**EL PASO COUNTY PLANNING AND
 COMMUNITY DEVELOPMENT
 DEPARTMENT**

STORMWATER MANAGEMENT PLAN CHECKLIST

Revised: July 2019

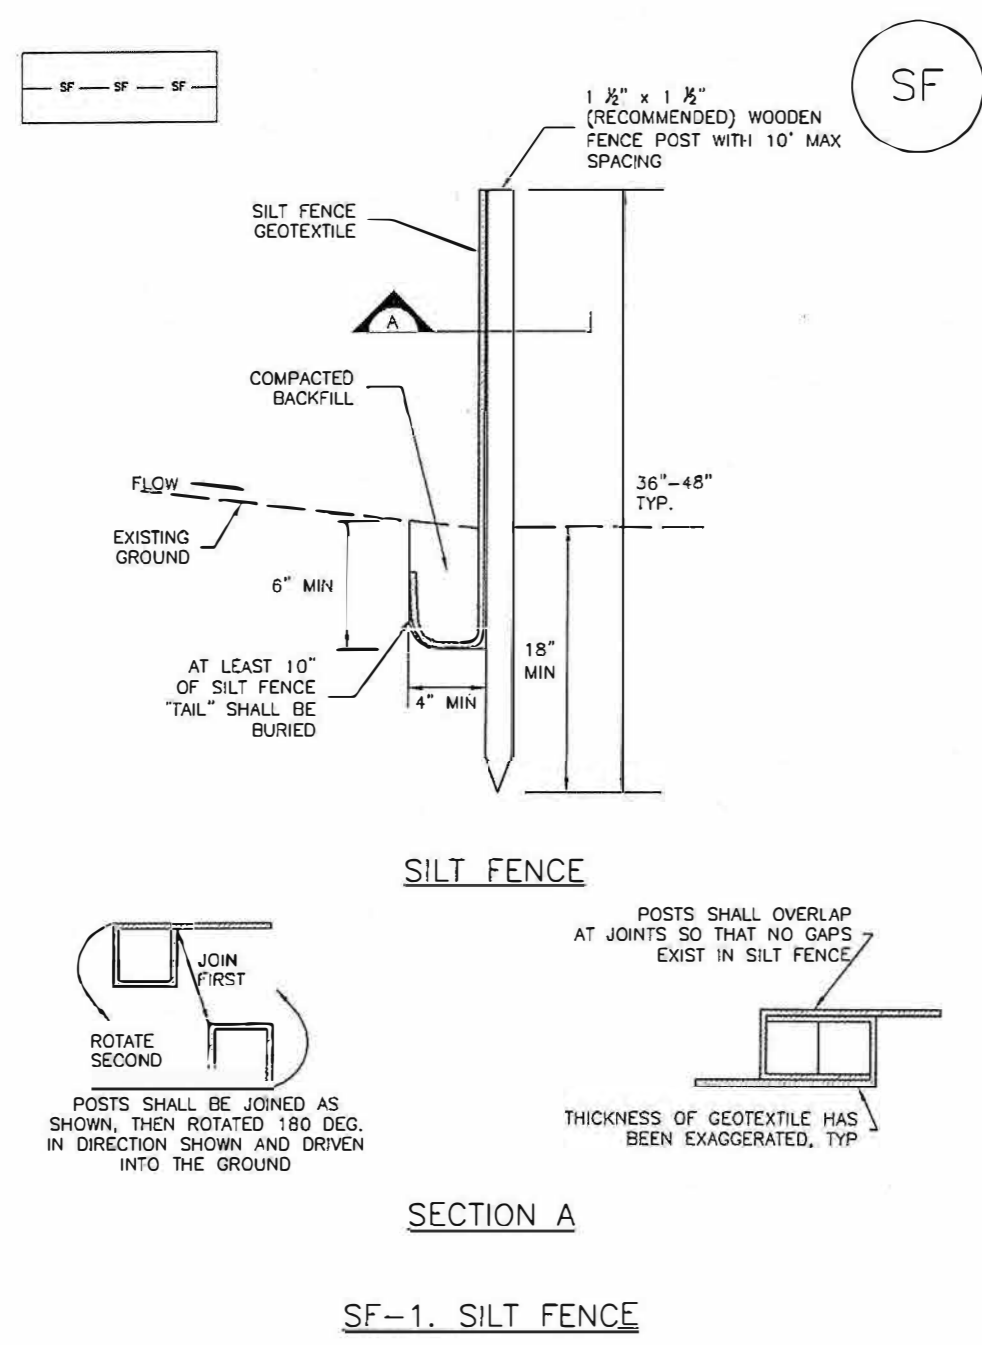
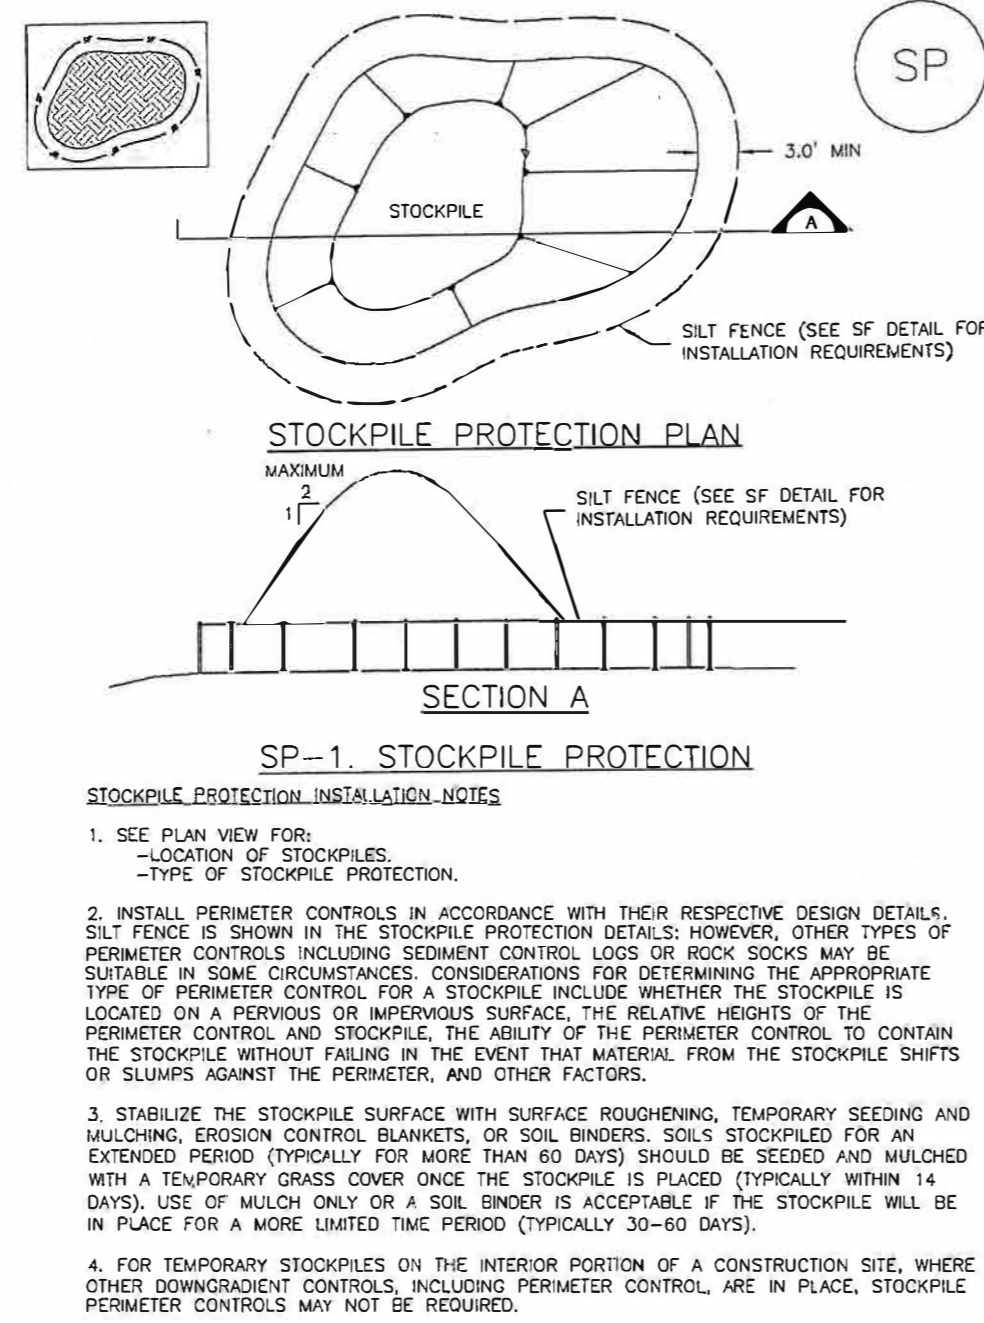
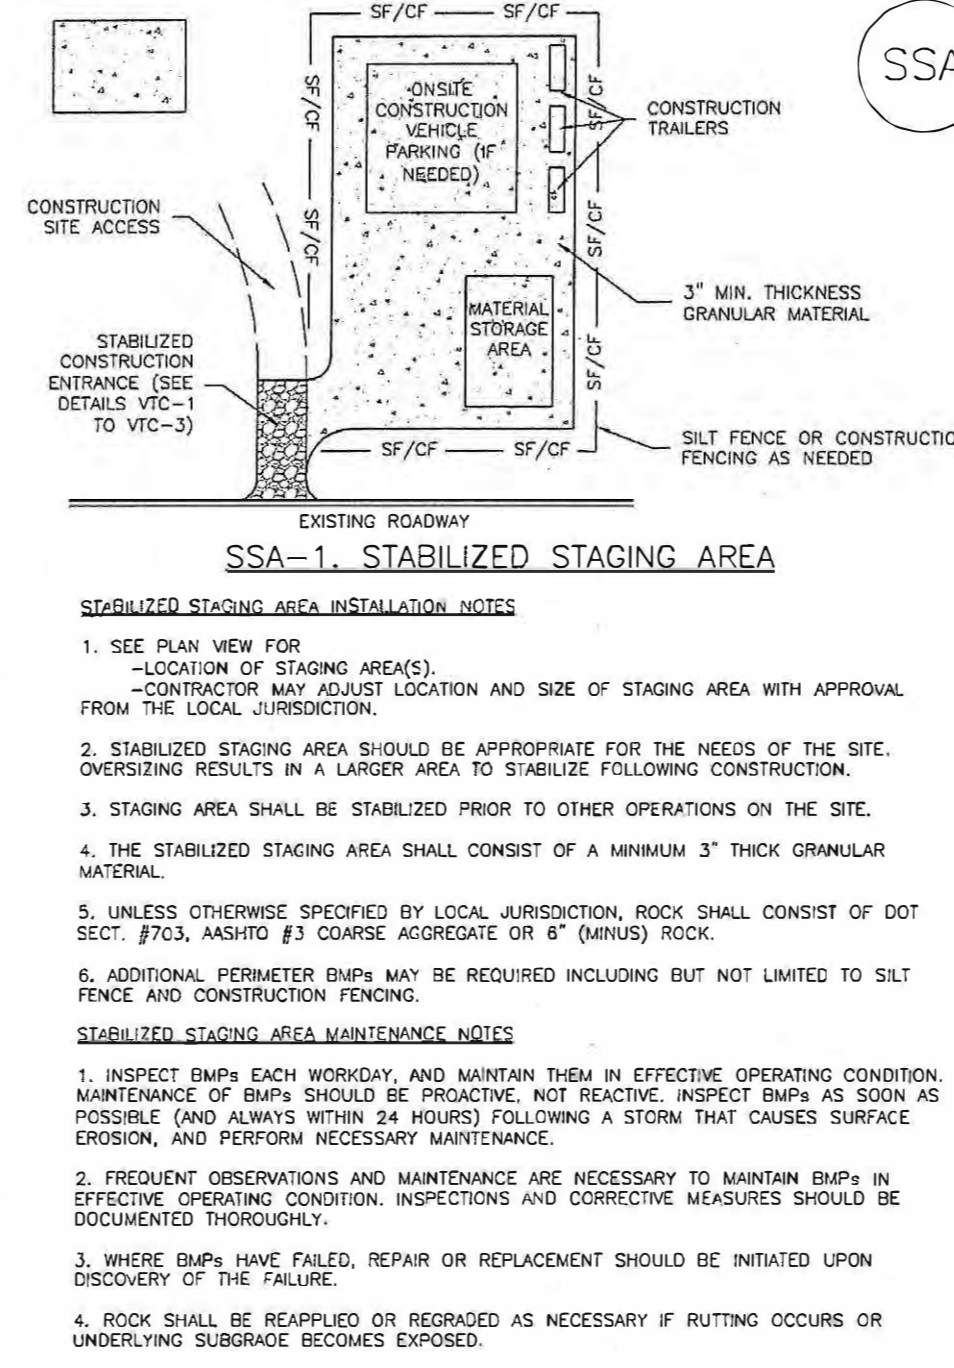
20	Technical drawing details for all control measure installation and maintenance, custom or other jurisdiction's details used must meet or exceed EPC standards see GEC_v2	X	X
21	Procedure describing how the SWMP is to be revised	X	✓
22	Description of Final Stabilization and Long-term Stormwater Quality (describe nonstructural and structural measures to control SW pollutants after construction operations have been completed, including detention, water quality control measure etc.)	X	✓
23	Specification that final vegetative cover density is to be 70% of pre-disturbed levels	X	✓
24	Outline of permit holder inspection procedures to install, maintain, and effectively operate control measures to manage erosion and sediment	X	✓
25	Record keeping procedures identified to include signature on inspection logs and location of SWMP records on-site	X	✓
26	If this project relies on control measures owned or operated by another entity, a documented agreement must be included in the SWMP that identifies location, installation and design specifications, and maintenance requirements and responsibility of the control measure(s).	X	✓
